**RE: Panda Express at 2040 Gibson Blvd SE (Lot C-2 Lovelace Heights Addition.)
Erosion and Sediment Control Plan
Engineer's Stamp date 03/5/2025 (M15E021F) SWQ-2025-00012**

Civil Engineering Services, PC (CES) is in receipt of your comments, from March 11, 2025. Below are our responses to your comments. Please include this document in your review of the proposed plans.

C06.1

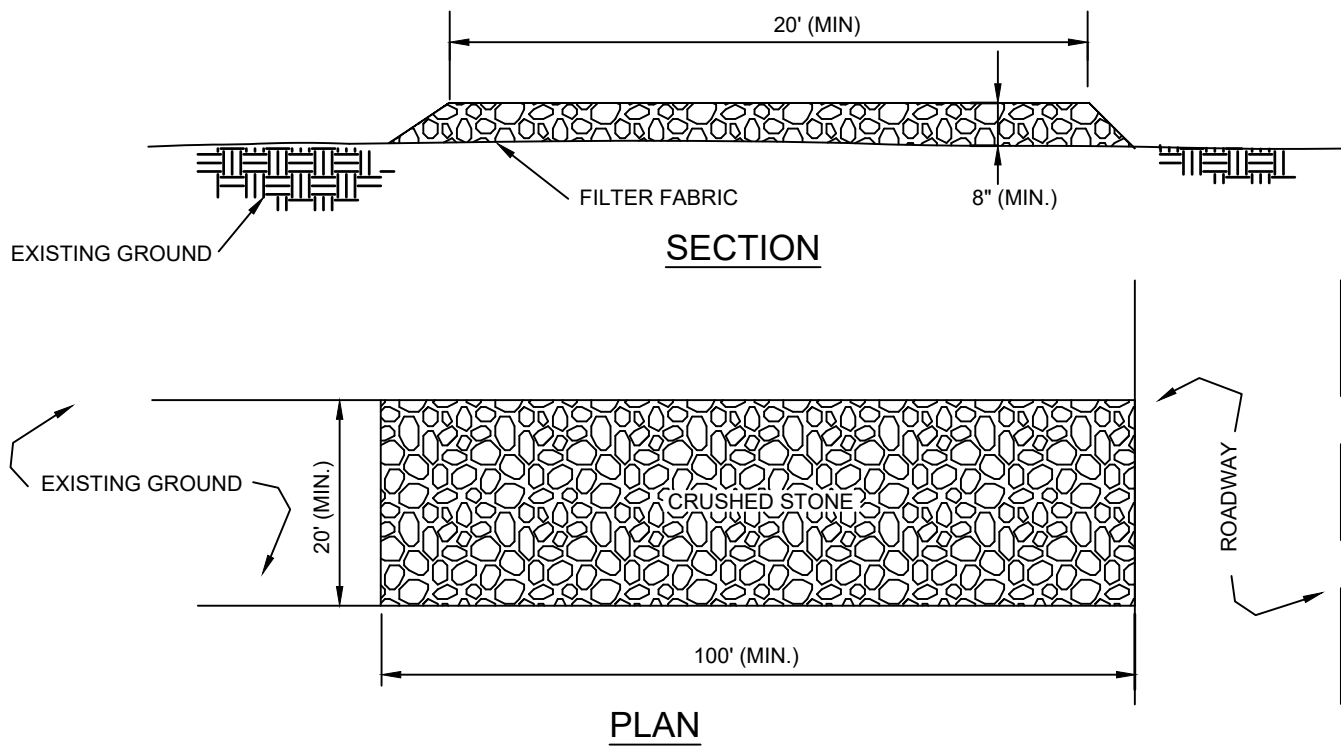
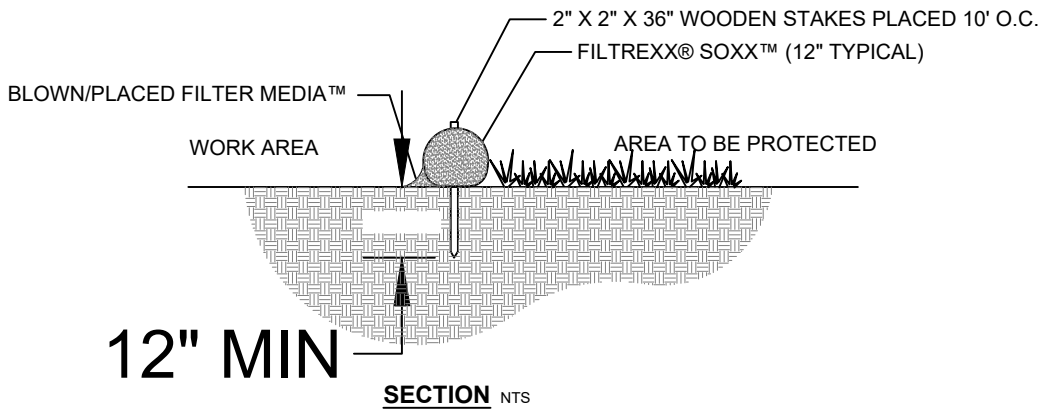
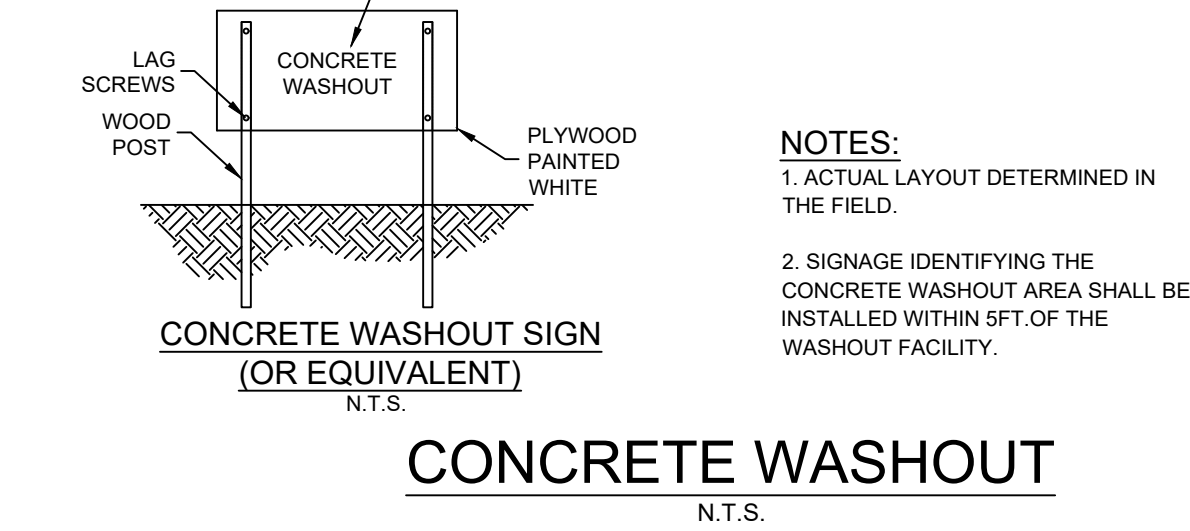
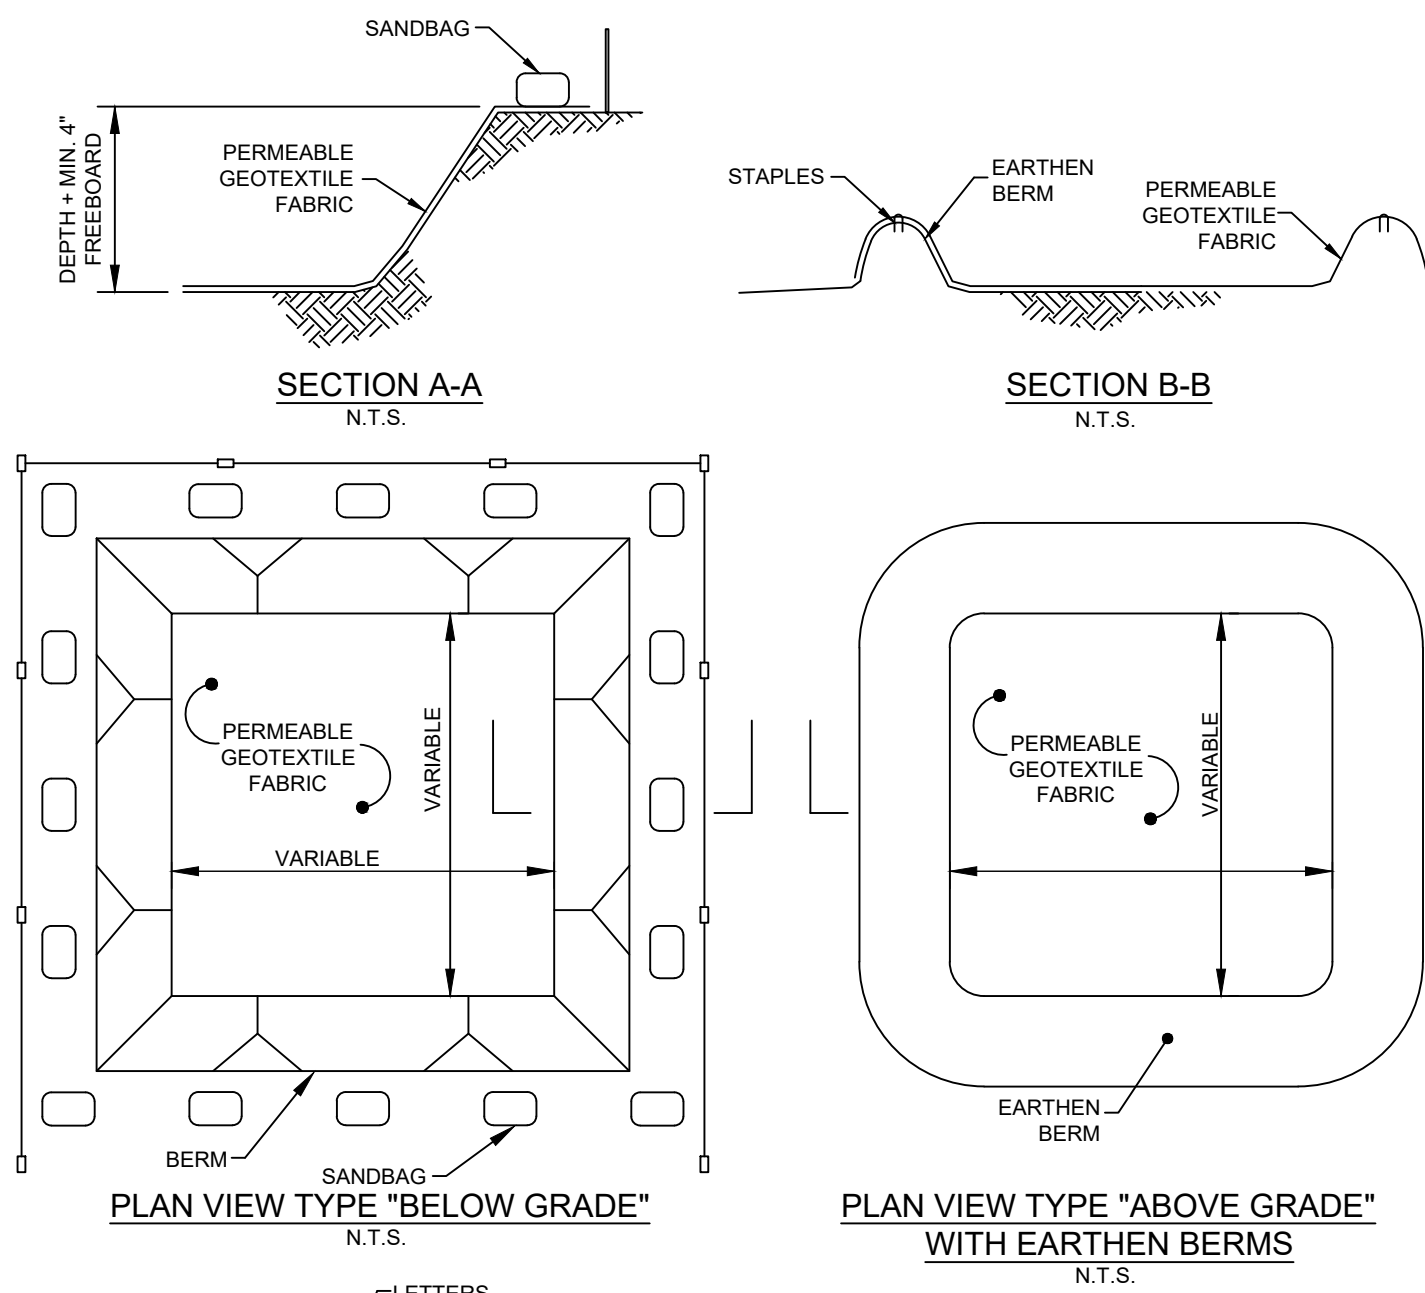
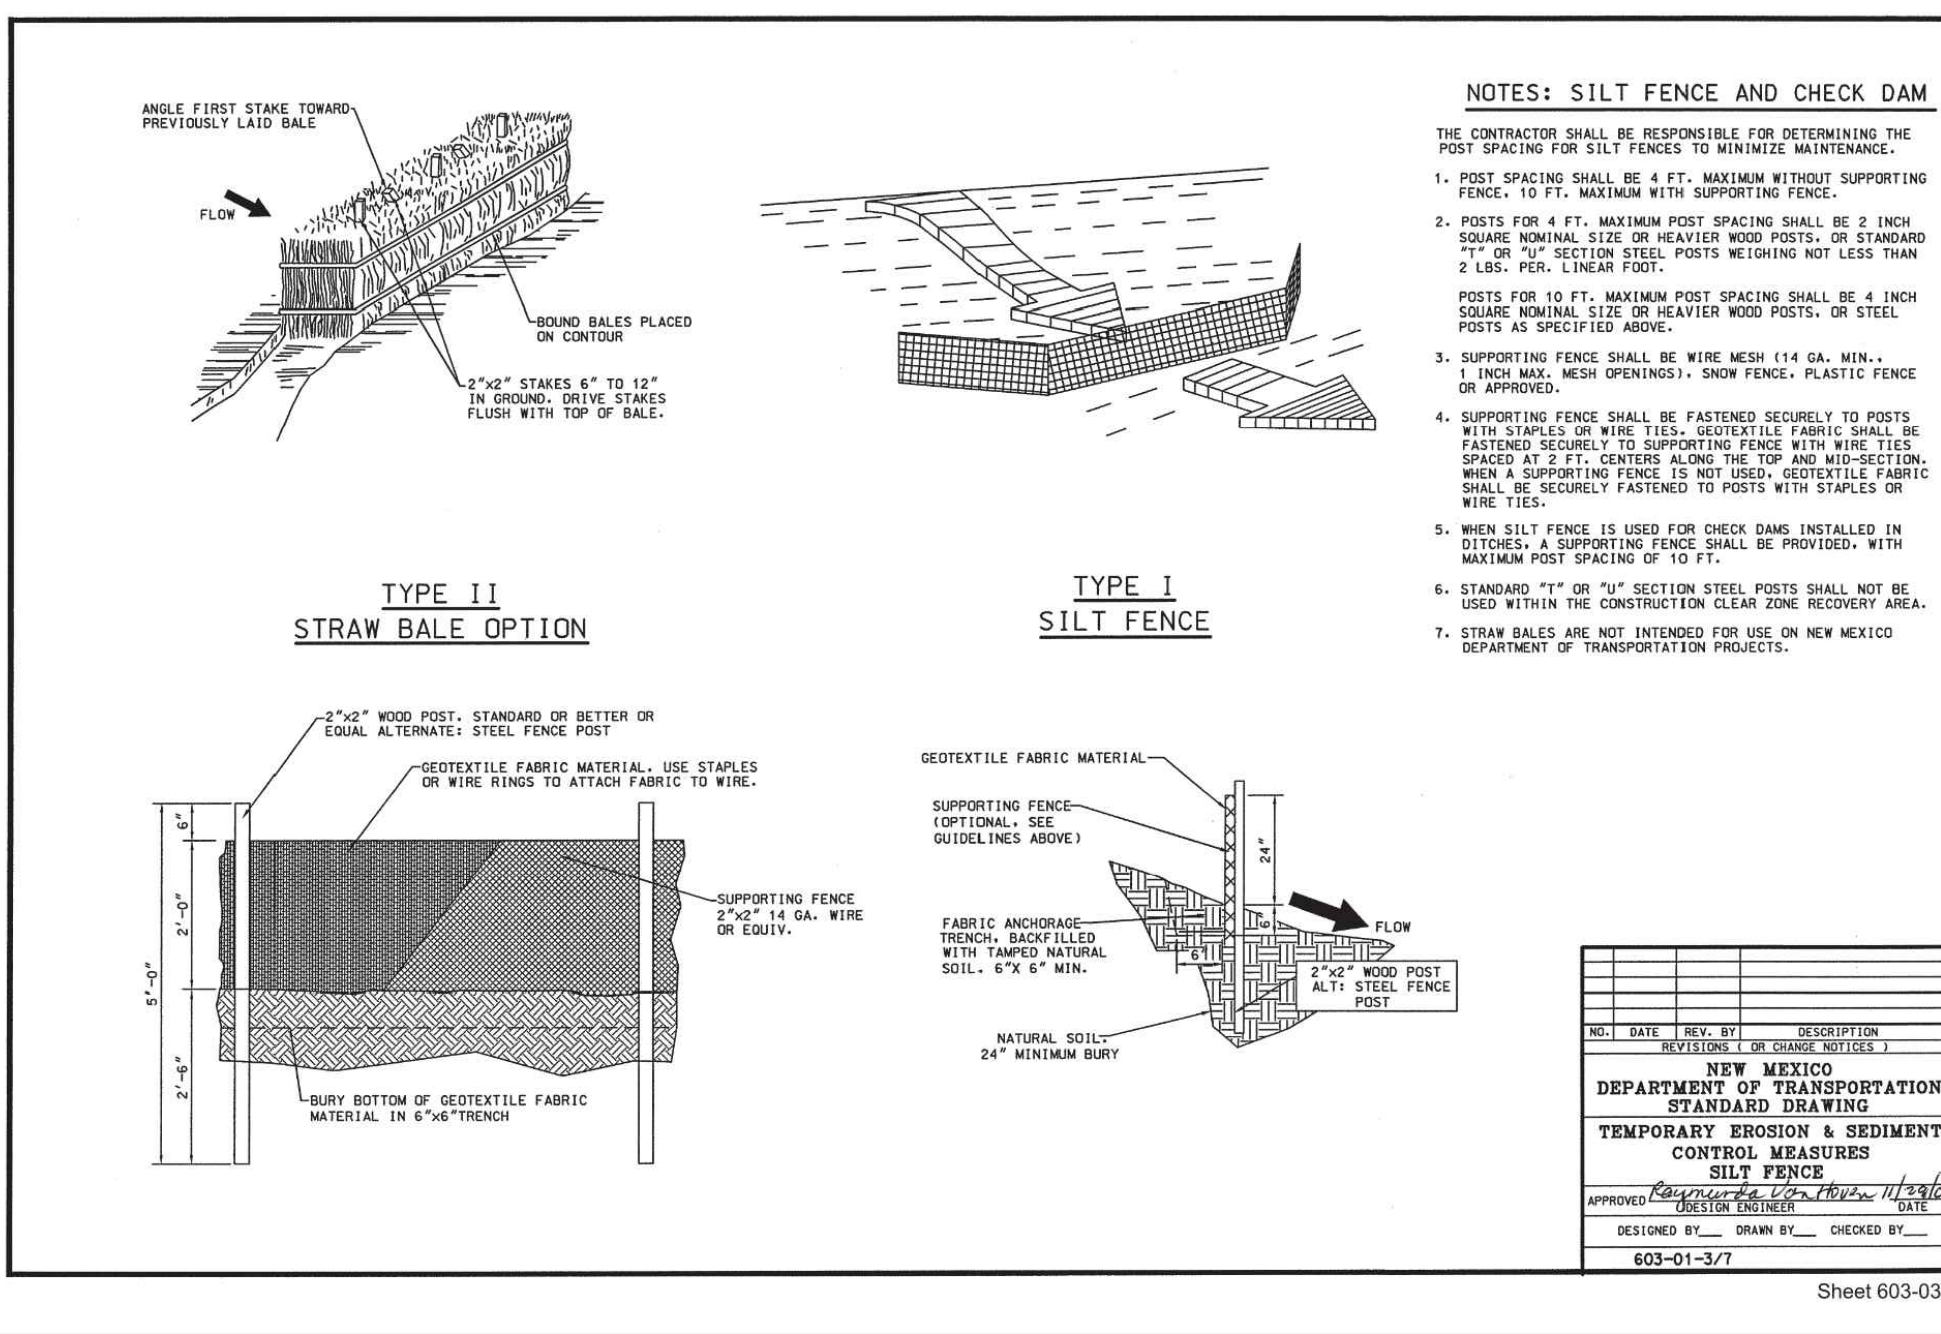
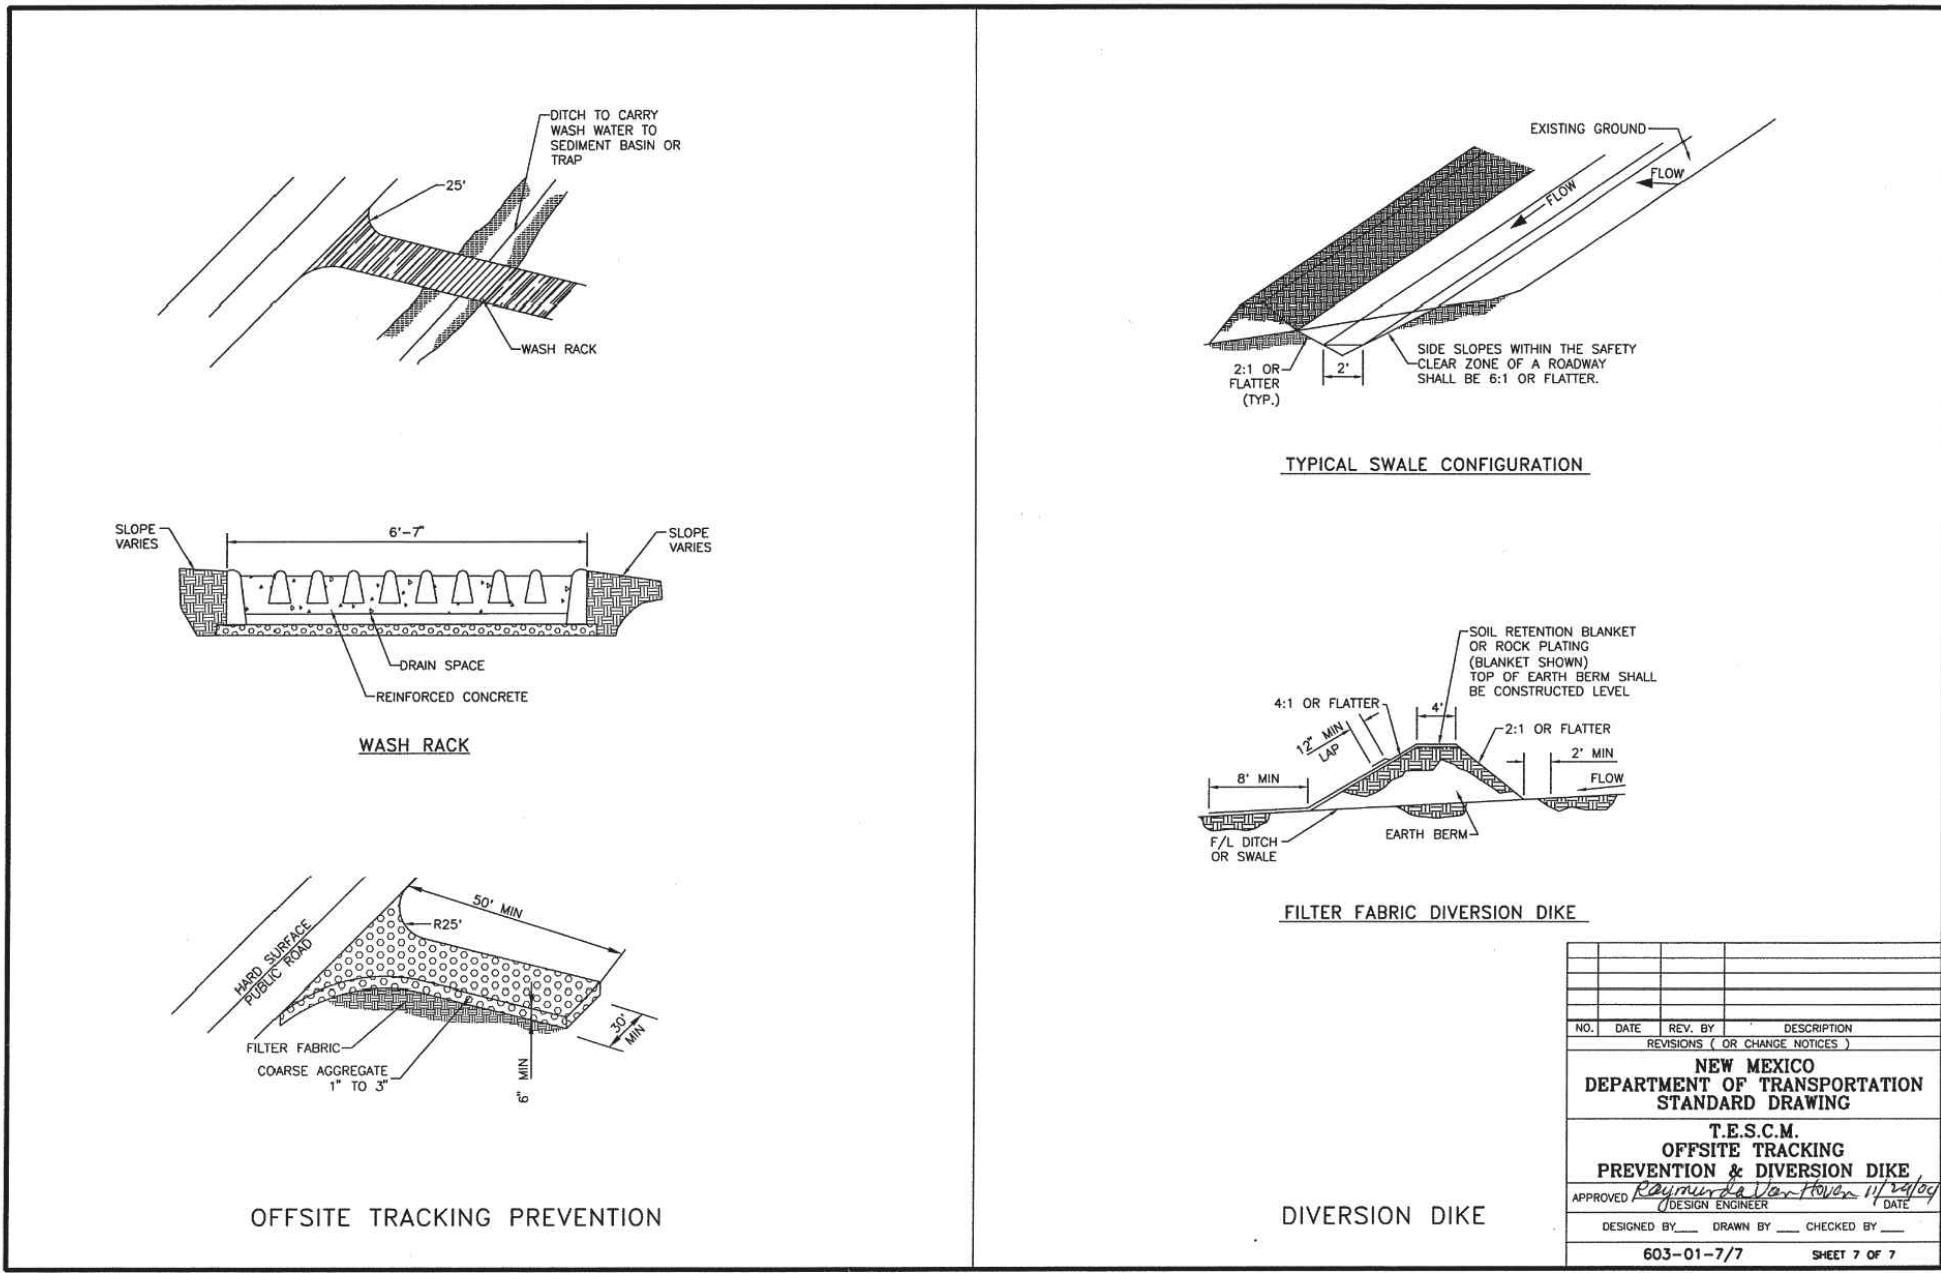
7. Construction details and specifications are missing from the ESC Plan for most of the stormwater controls, including but not limited to Stockpile Management, Silt Fence, Diversion Berms, and Sediment Traps. NMDOT has details for most of these BMPs at NMDOT NPDES Manual Rev 4 2023 in Appendix A. Mulch socks don't seem appropriate, but if used, they should be staked per NMDOT detail instead of weighted down. **The ESC Plan, Sheet C06.0, was missing from the resubmittal, so the controls are unknown.**

Response: Details are added see detail sheet C06.1.

Response: See Landscape plan attached. Section 7 added to ESC. Aggregate added to offsite grading see keynote 11 on sheet C06.0 and detail 1013-SKL-1 on Sheet C06.1
